Gatwick Airport Northern Runway Project

Examination Ref: TR020005

Joint Local Authorities Response to the Applicants Deadline 4 Submissions and response to the Applicants Written summary of oral submissions ISH6. ISH7 and CAH1

Deadline 5: 6 June 2024

Title:
Ordnance Survey Base Map Identifying Category 3 and Noise Insulation Scheme Boundary - Sheet 1 of 4

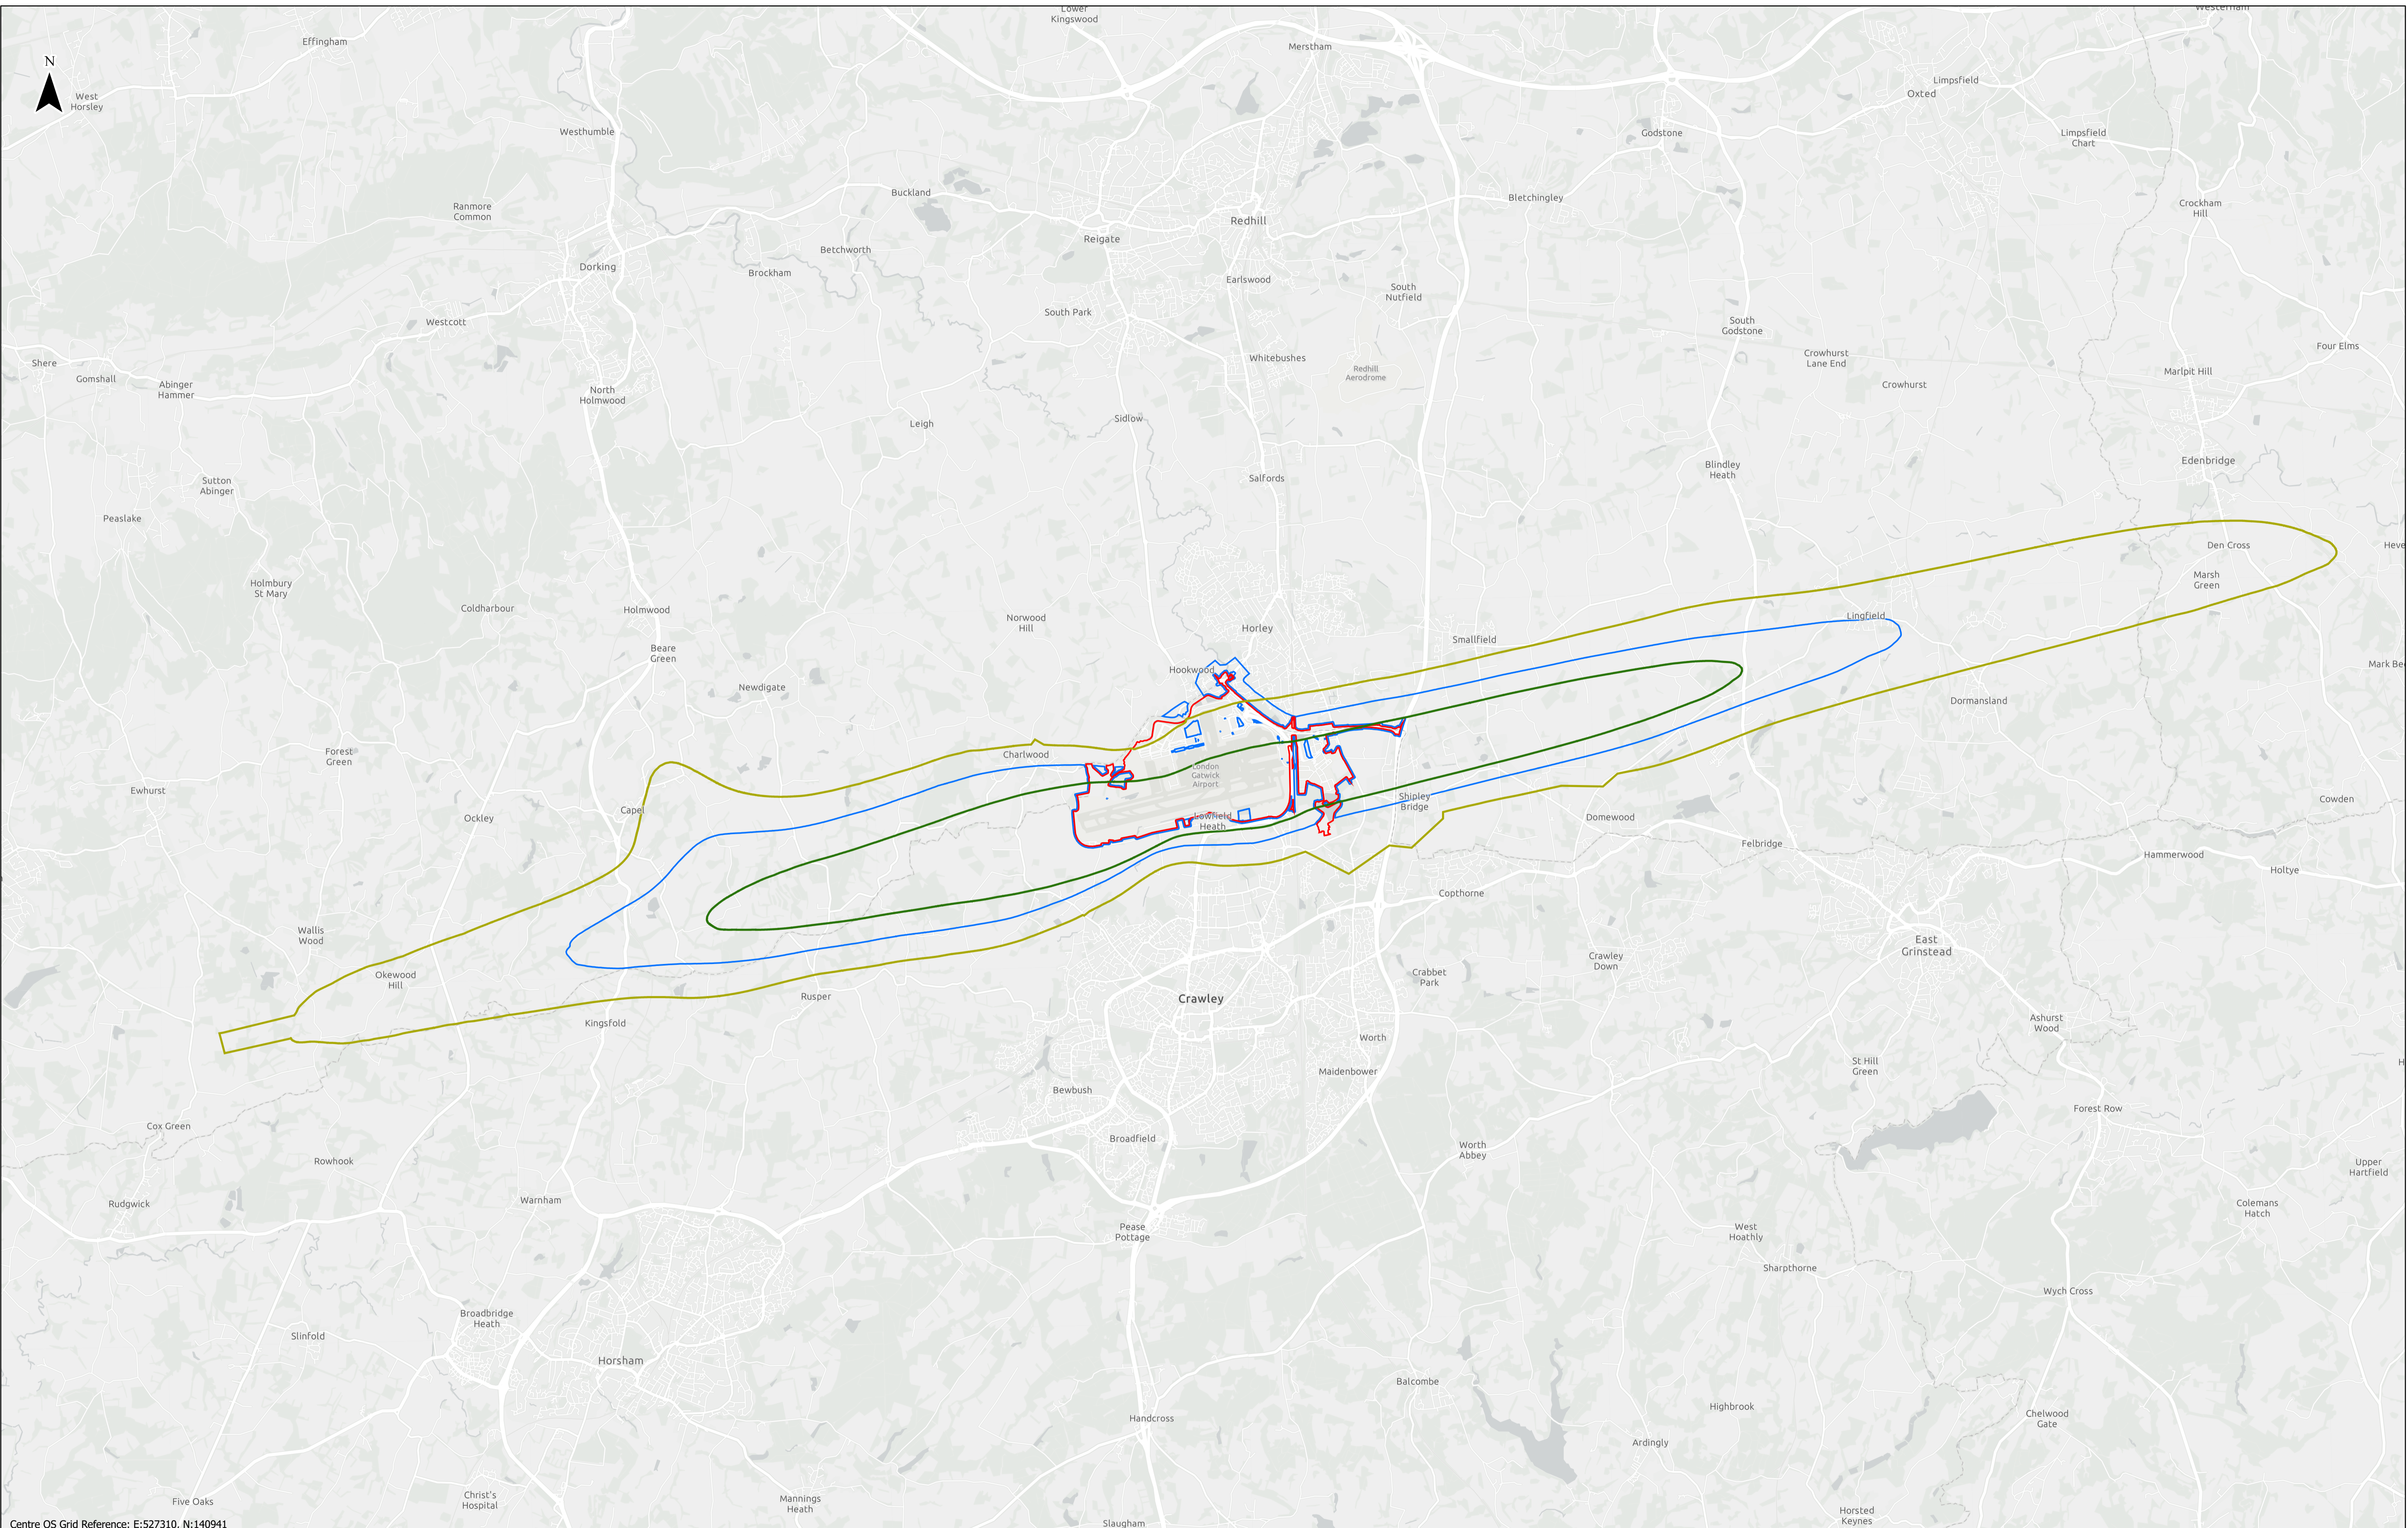
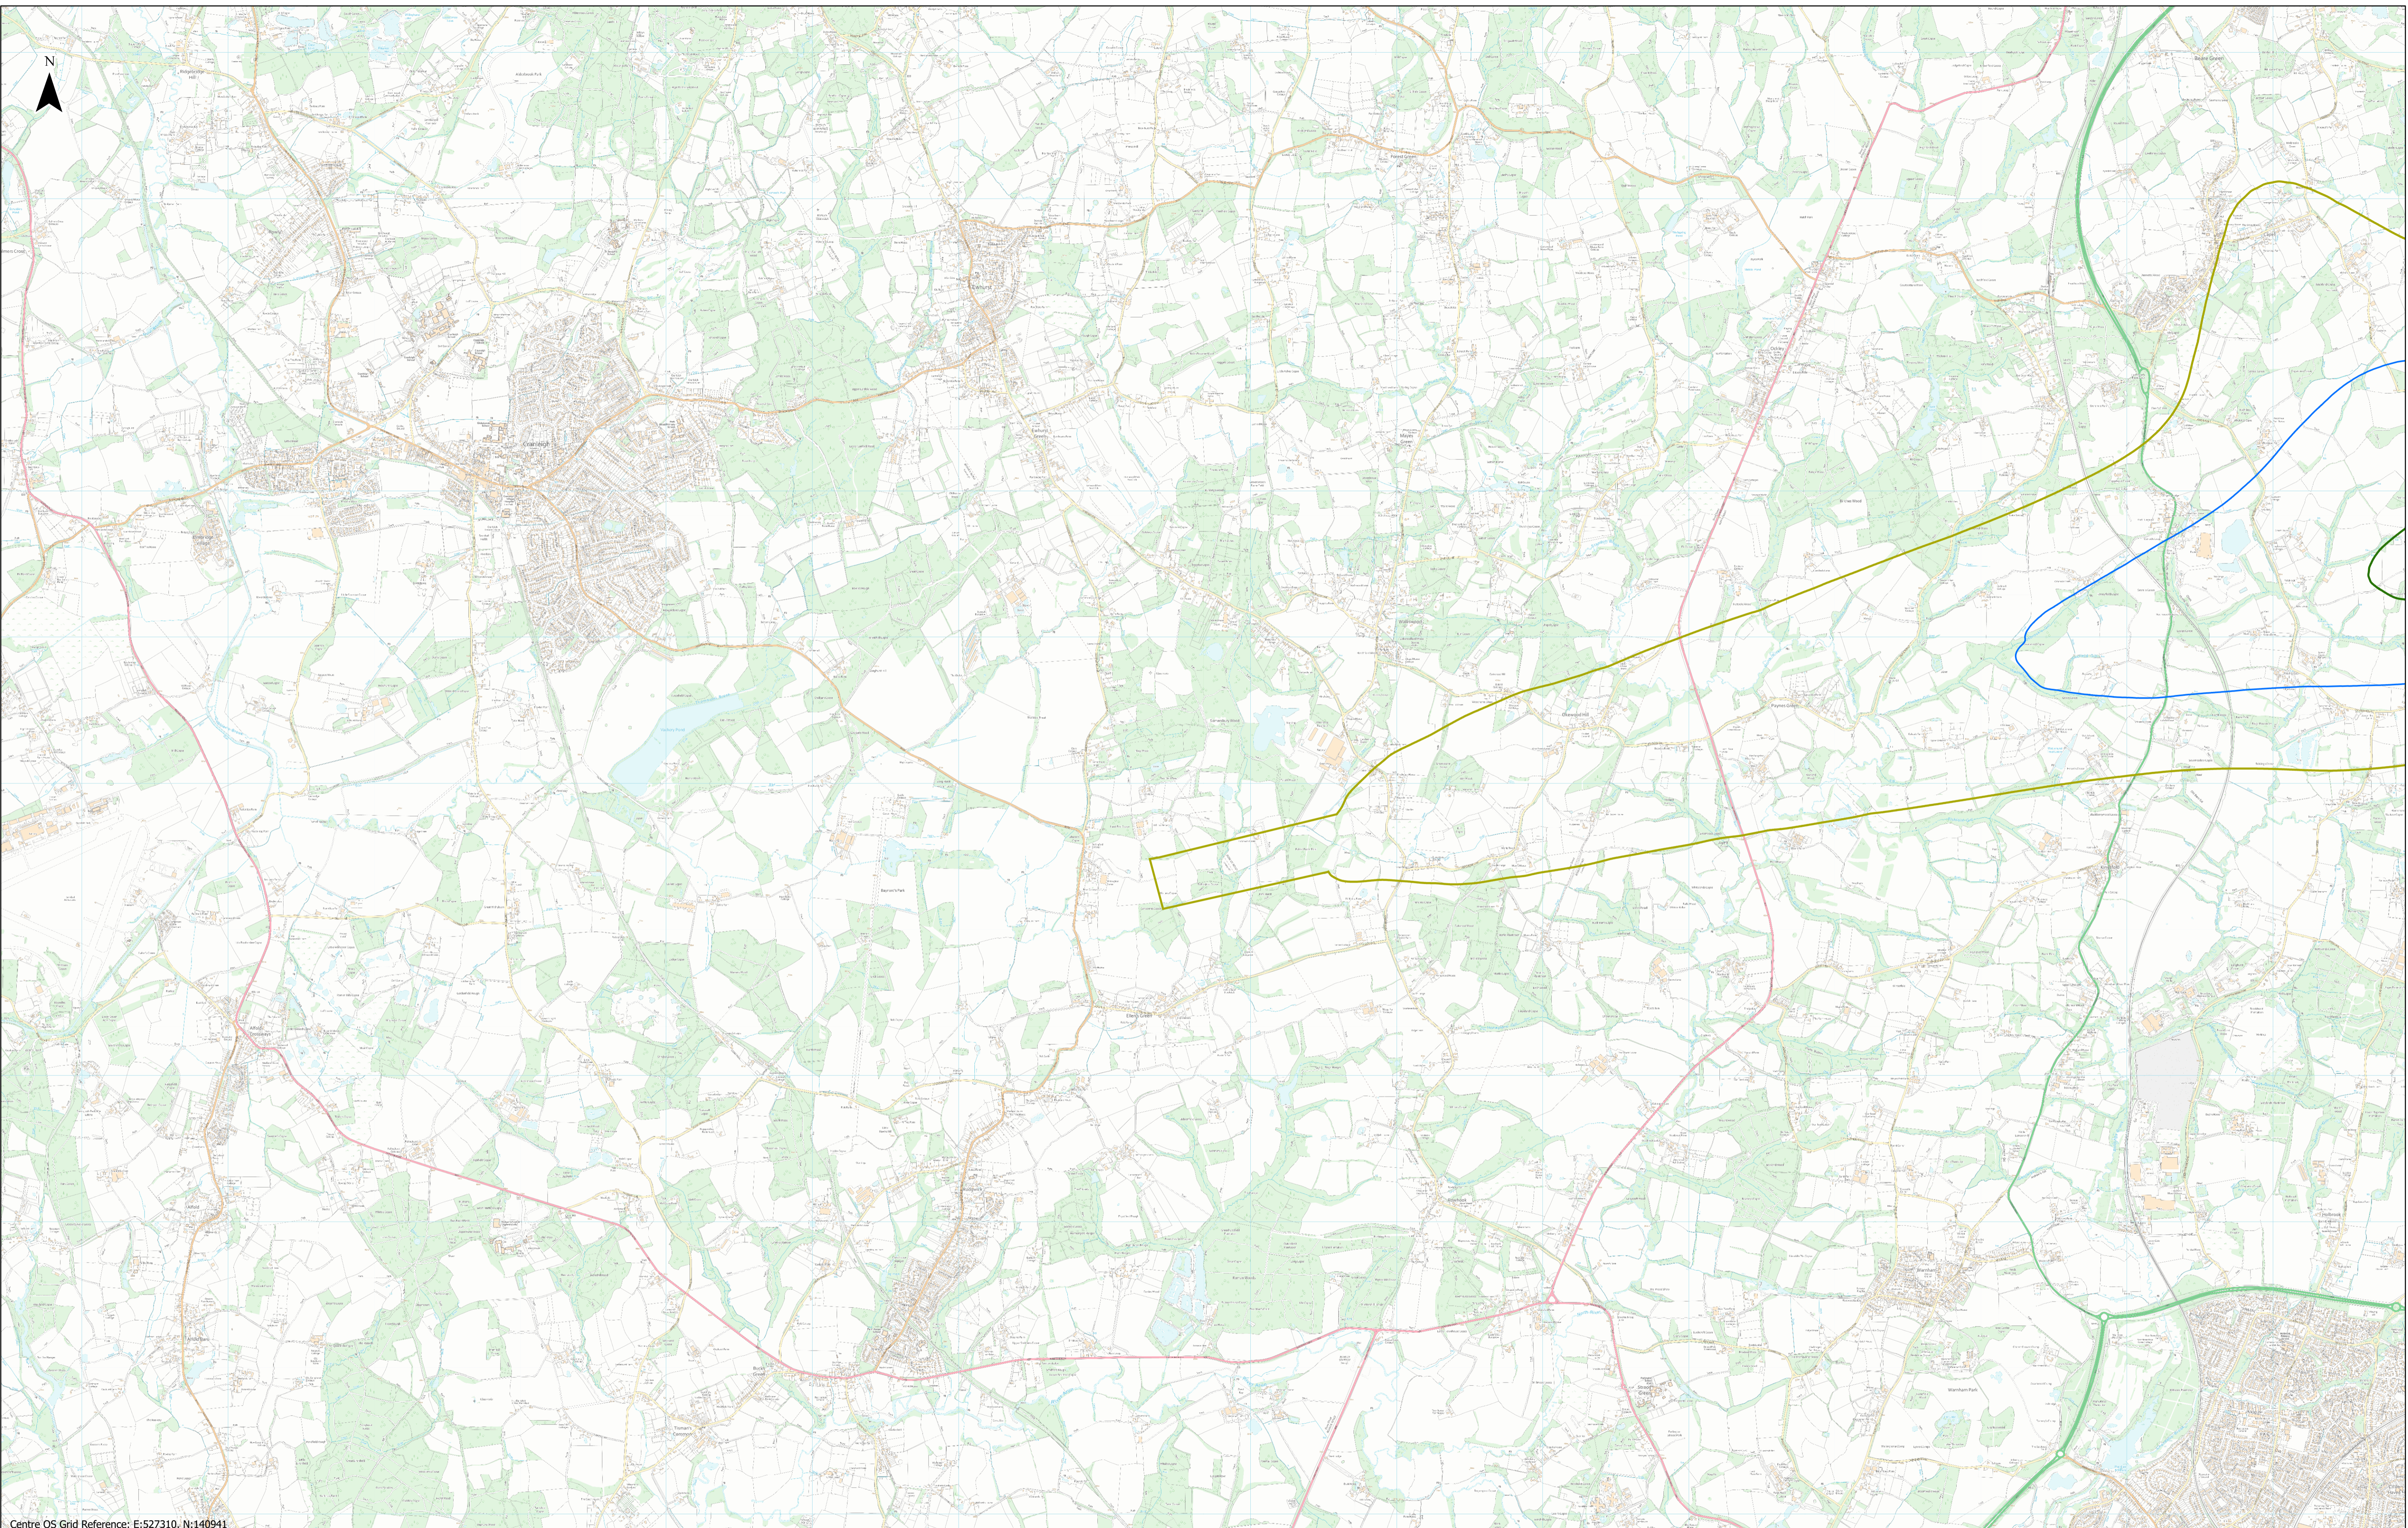
- 3.9 The JLAs believe that the scheme should be based on the single mode contours. The designation of the extent of the inner and outer zones should be by agreement with the Local Planning Authority. Rather than rely on the precise extent of a polygon on a geographic information system produced by a model, the extent of the insulation zone should be adjusted to take into account the extent of any built up areas and the zone extended accordingly. This adjustment existed under the previous scheme but it appears to have been mostly dropped under the current proposal.

- 3.10 In addition to the general points above the JLAs make comment about specific paragraphs below.
- Eligibility for ground noise insulation should be included in the Outer Zone. Ground noise eligibility should be based on ground noise predictions so insulation can be provided before significant effects occur.

- What noise contours will eligibility for the noise insulation scheme be based on?
- Paragraph 4.1.4. The JLAs consider that as an average 8 hour night value, when taken over the 92 day summer period, the one additional noise induced awakening due to aircraft noise must also be set as the extent of the inner zone for noise insulation purposes.
